**REQUEST**

Approximately 84.16 acres located on the north and south side of Sardis Lane, and east side of Providence Road.

The petition proposes a mixed-use development on parcels that are currently developed with multi-family, commercial, outdoor and indoor recreation.

Levine Properties

SCHMATIC SITE PLAN

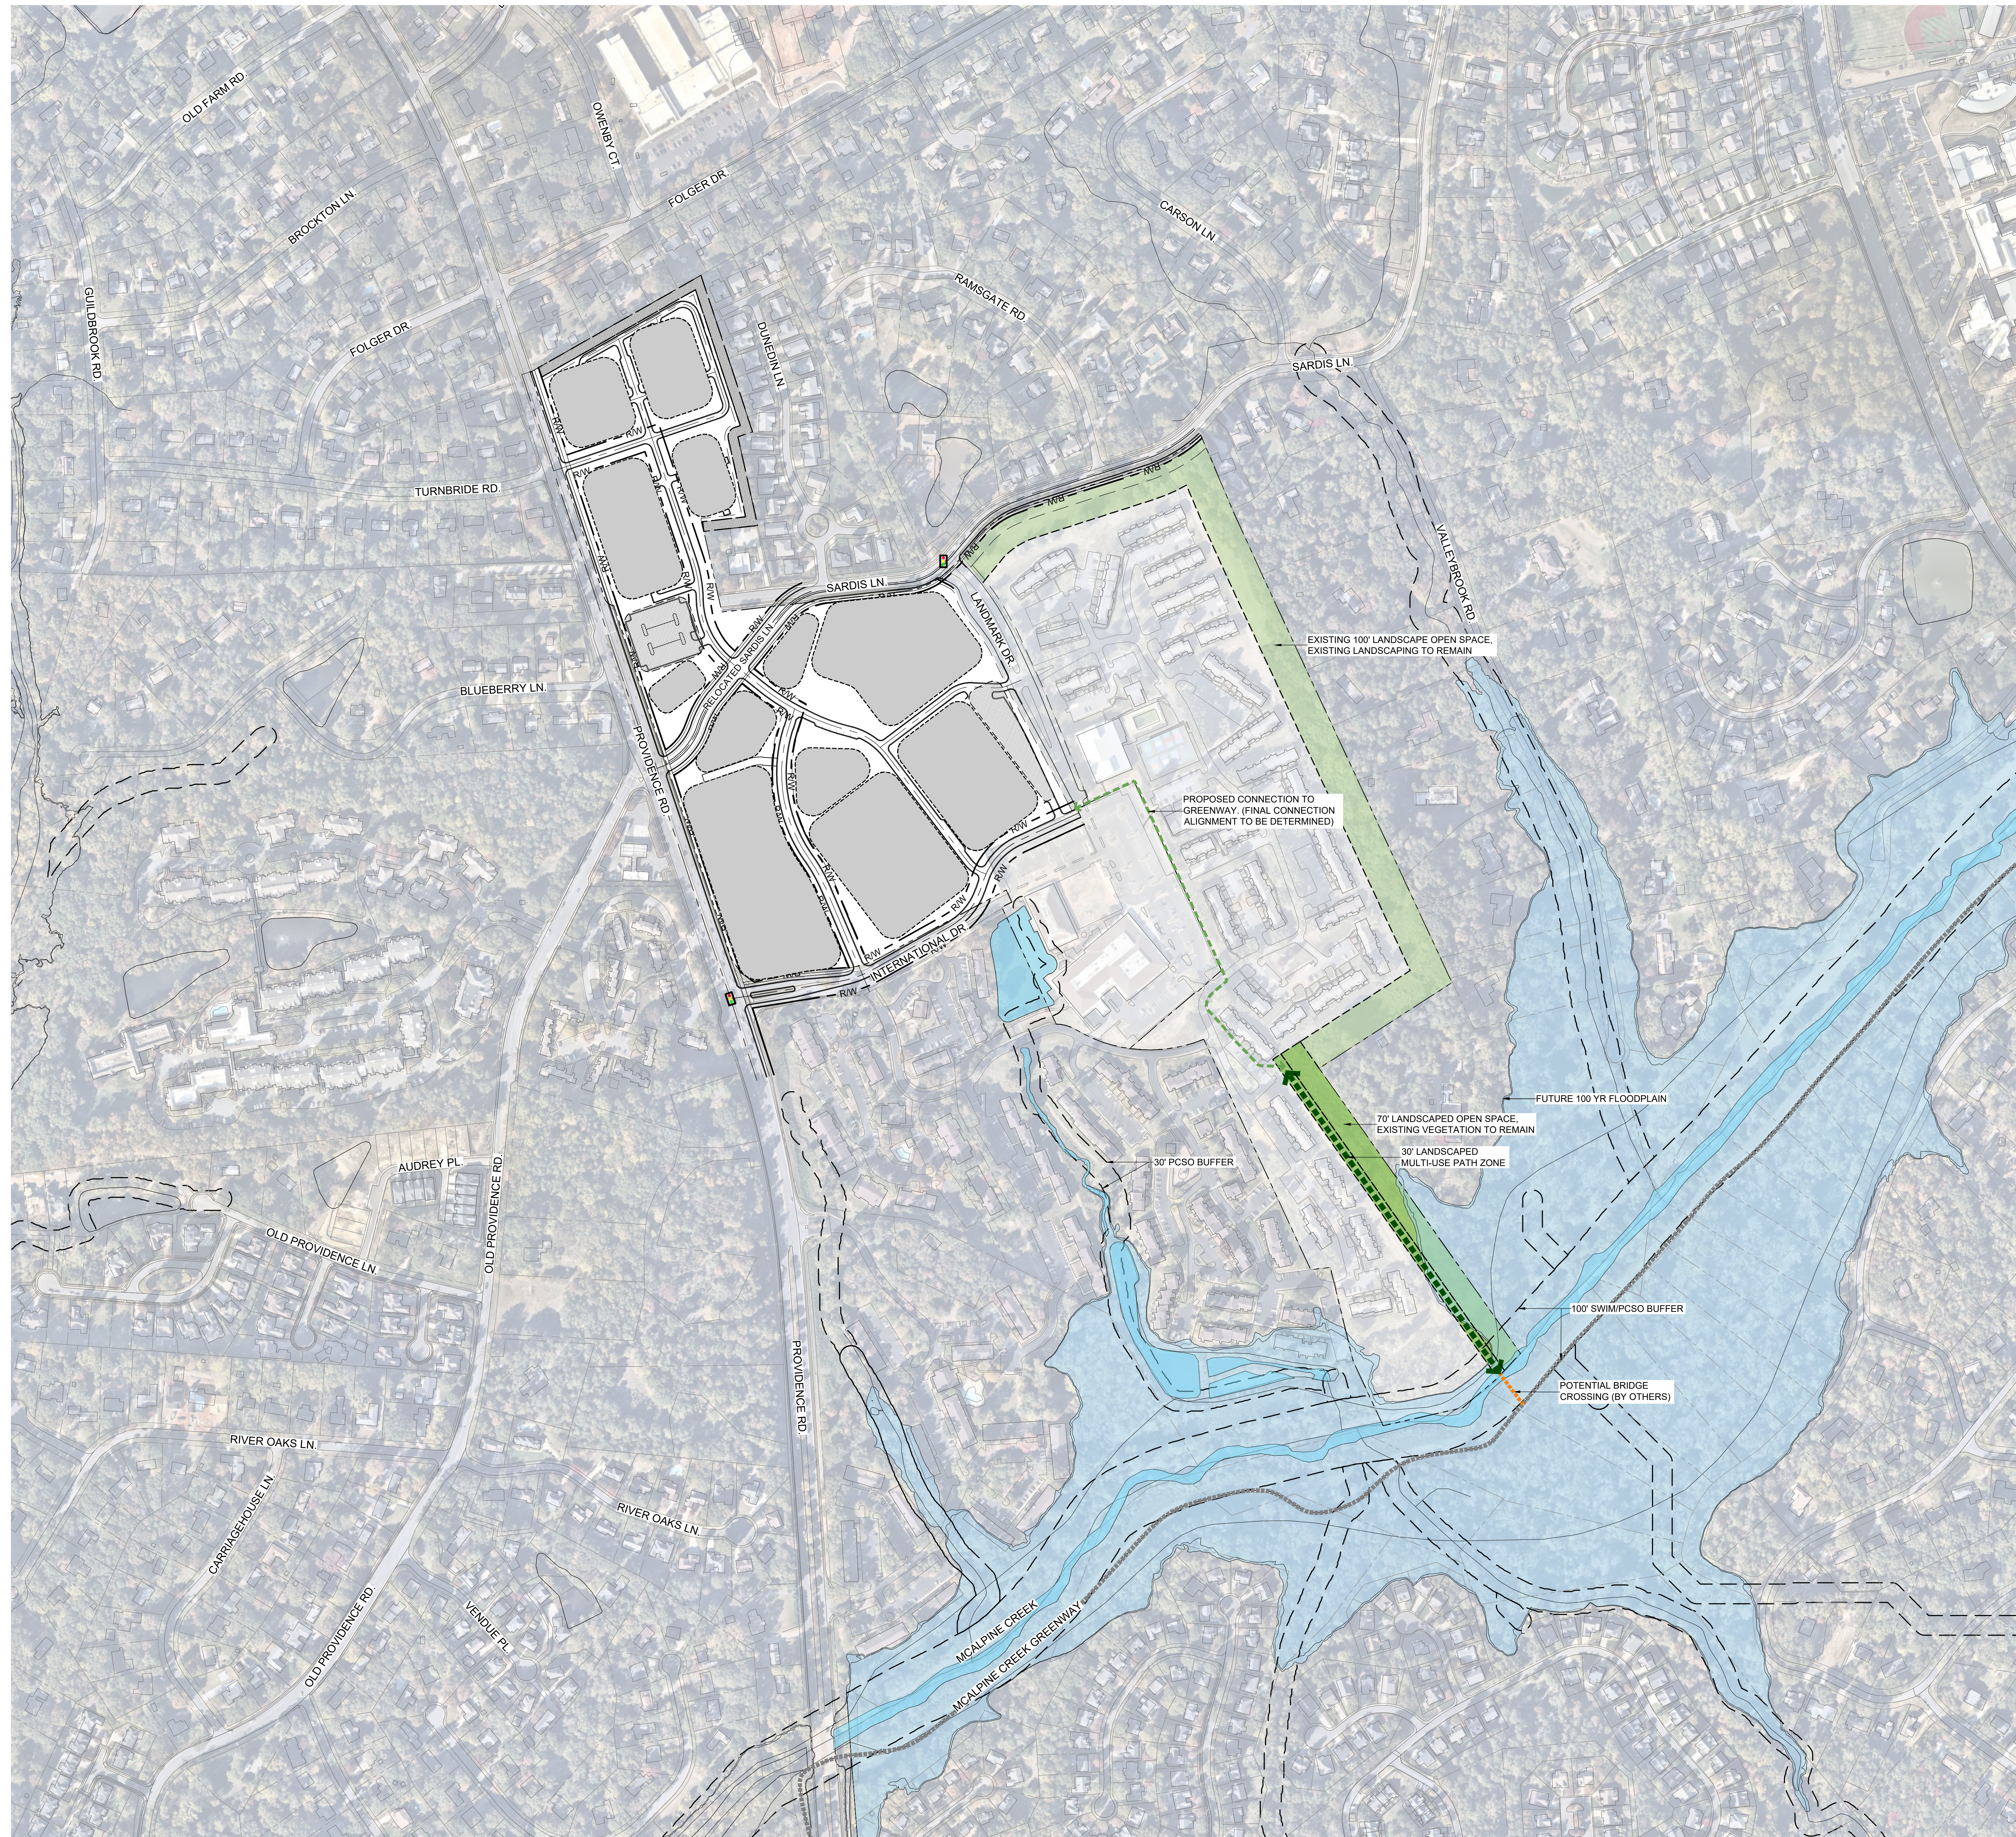
12. Clearly show proposed layout of Development Areas C and D.
13. Provide architectural and design standards for Development Areas C, D, and E that align with UDO and 2040 Comprehensive Plan recommendations.

14. Commit to a minimum sidewalk width of 8 feet for all public and network required private streets (other than Providence Road which will have a 12-foot MUP).
